3 February 2016

Our Reference: SYD08/00176/02
DP&E Ref: MP08_0016 MOD 2

SECTION 75W MODIFICATION FOR WAREHOUSE AND DISTRIBUTION FACILITY AT 133A LENORE DRIVE, ERSKINE PARK

133-145 LENORE LANE, ERSKINE PARK
SWEEP PATH ASSESSMENT
19.0m SEMI RIGID VEHICLE

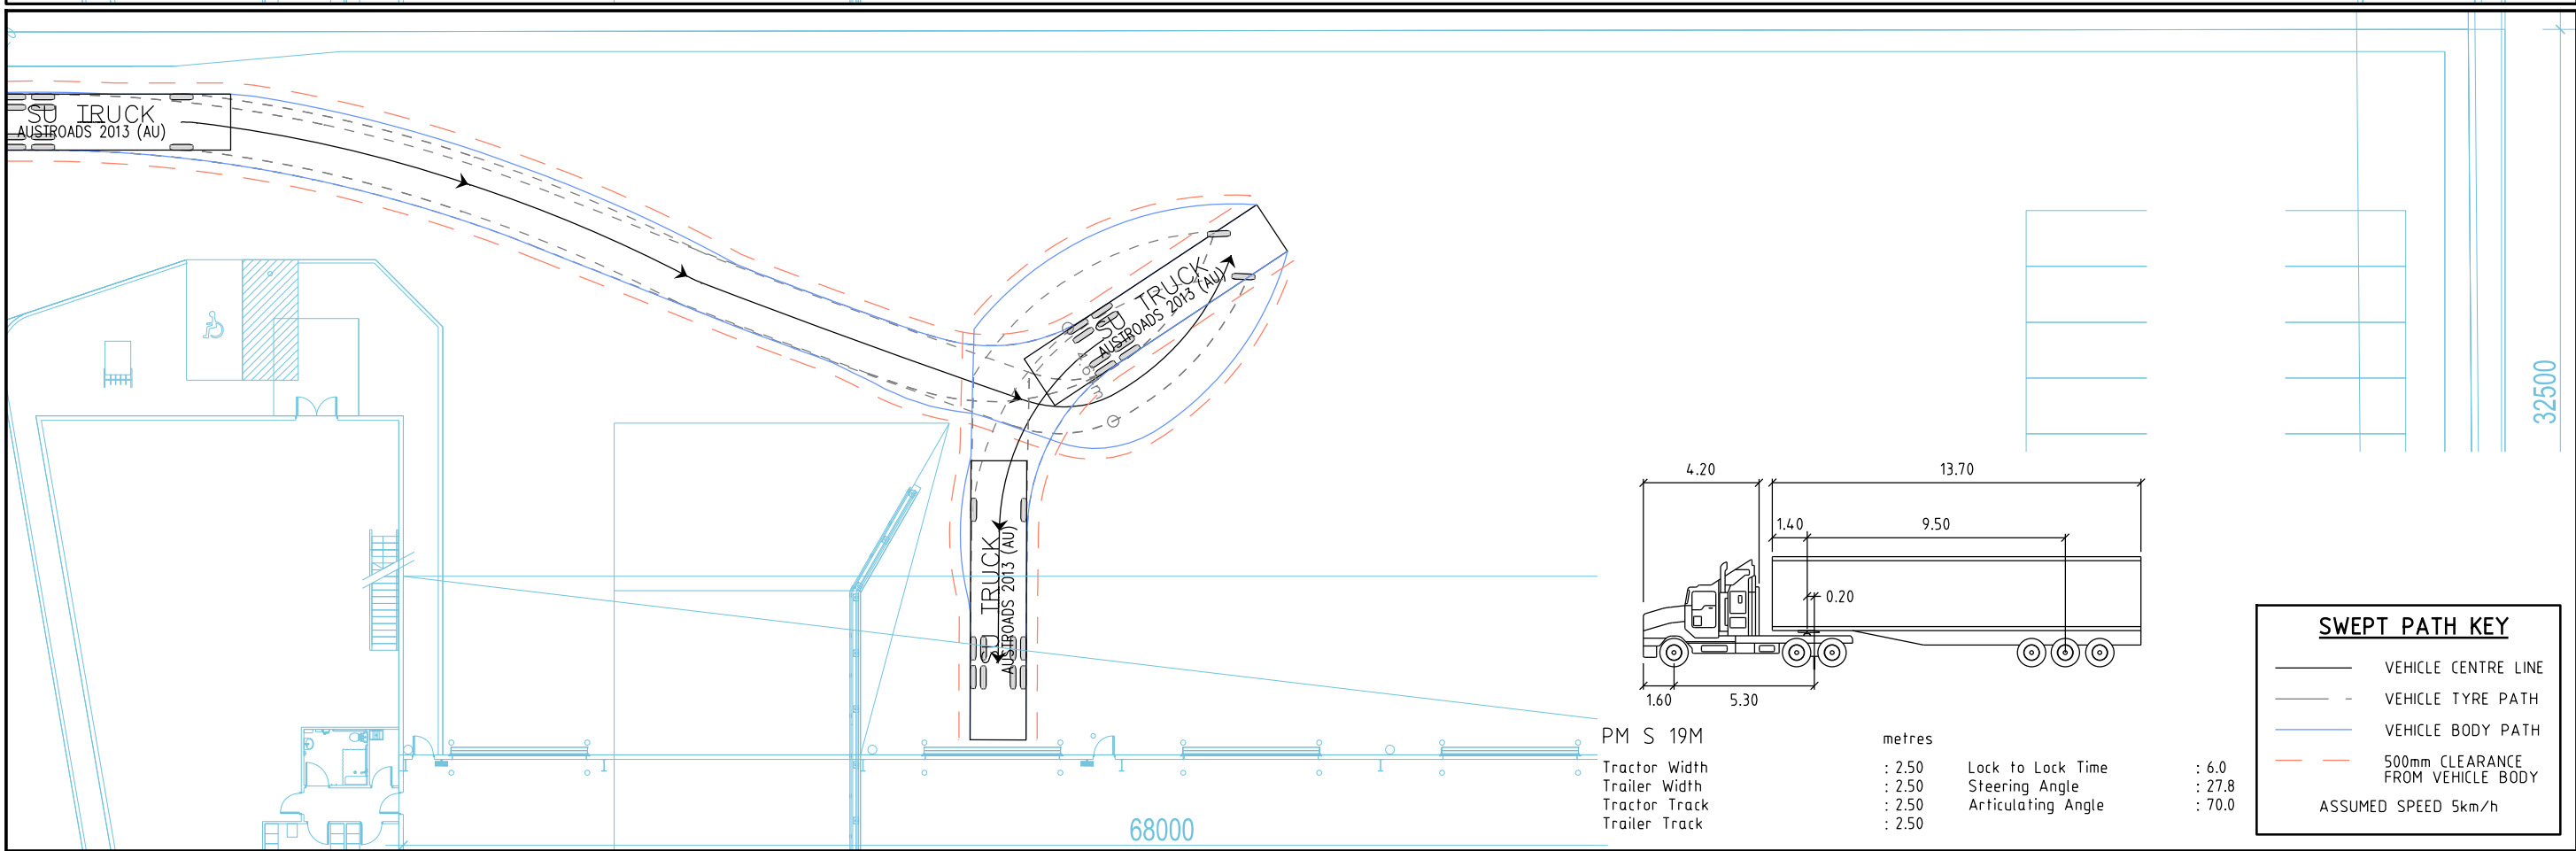
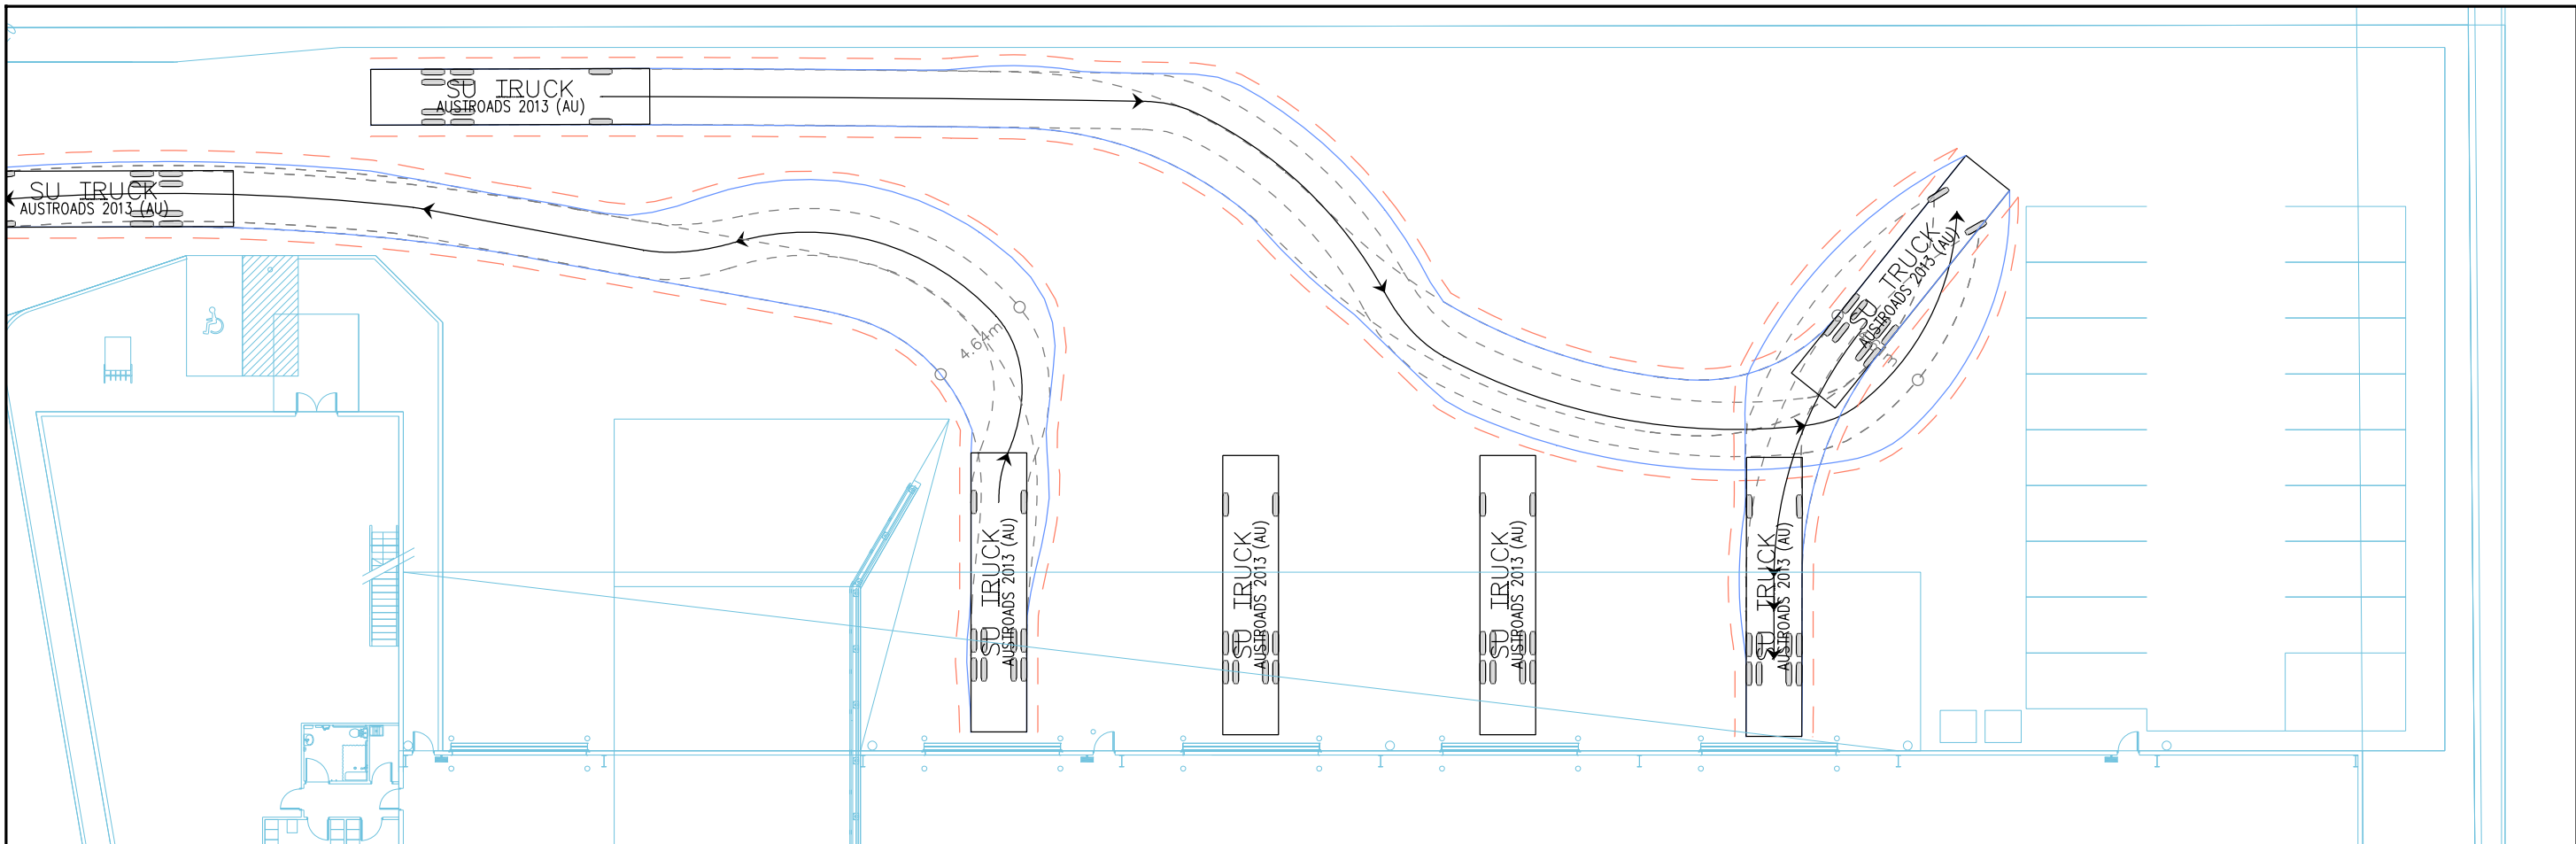
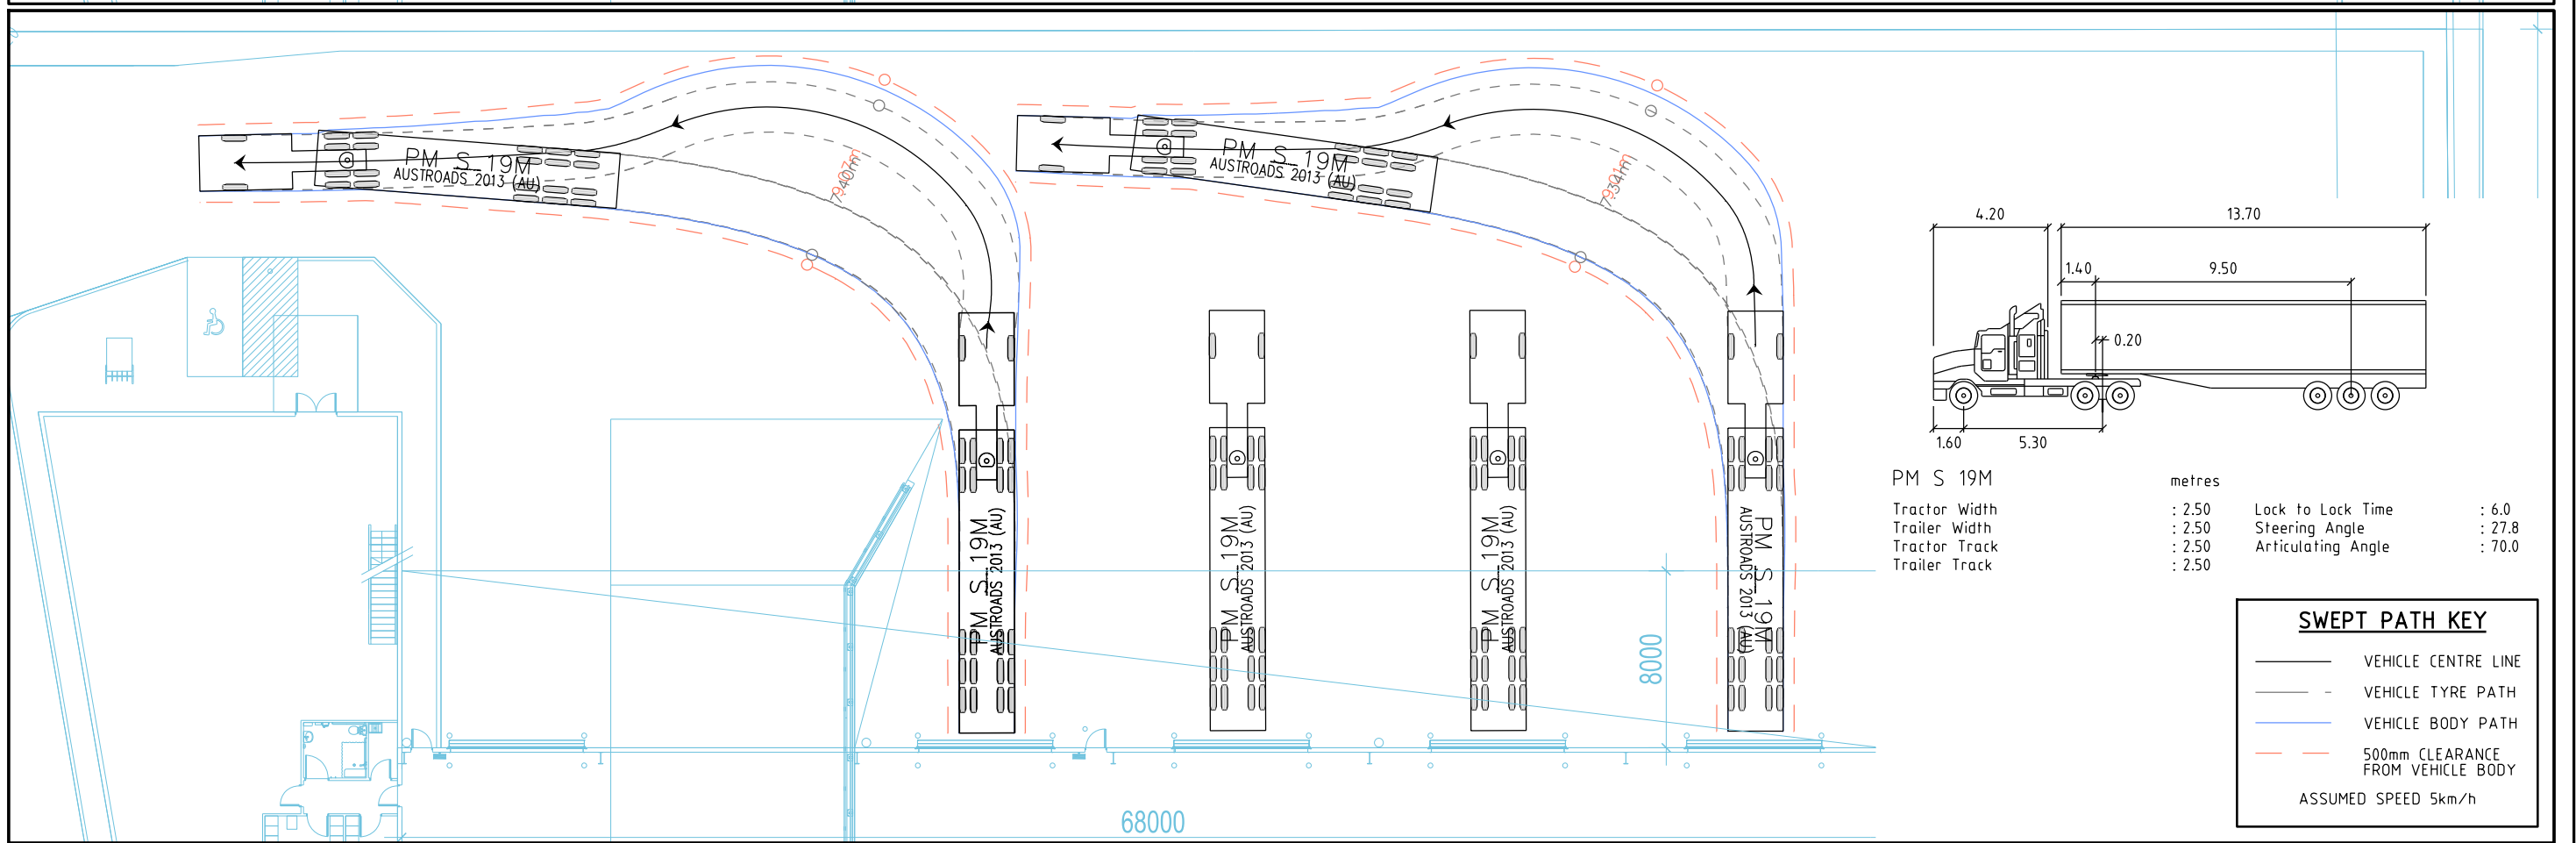
1. The design and construction of the combined car / truck driveway crossing at the western boundary of the site along Lenore Drive shall be in accordance with Roads and Maritime requirements and (Drawing No: ERSK-DA-002; Issue: 1; Dated: 16/12/15). Details of these requirements should be obtained from Roads and Maritime Services, Manager Developer Works, Statewide Delivery, Parramatta (telephone 8588 5947).

2. Vehicular movements to the combined car / truck driveway crossing at the western boundary of the site along Lenore Drive must be restricted to left-in / left-out movements

only. This will require the proponent to physically close the existing gap in the median island along Lenore Drive fronting the site.
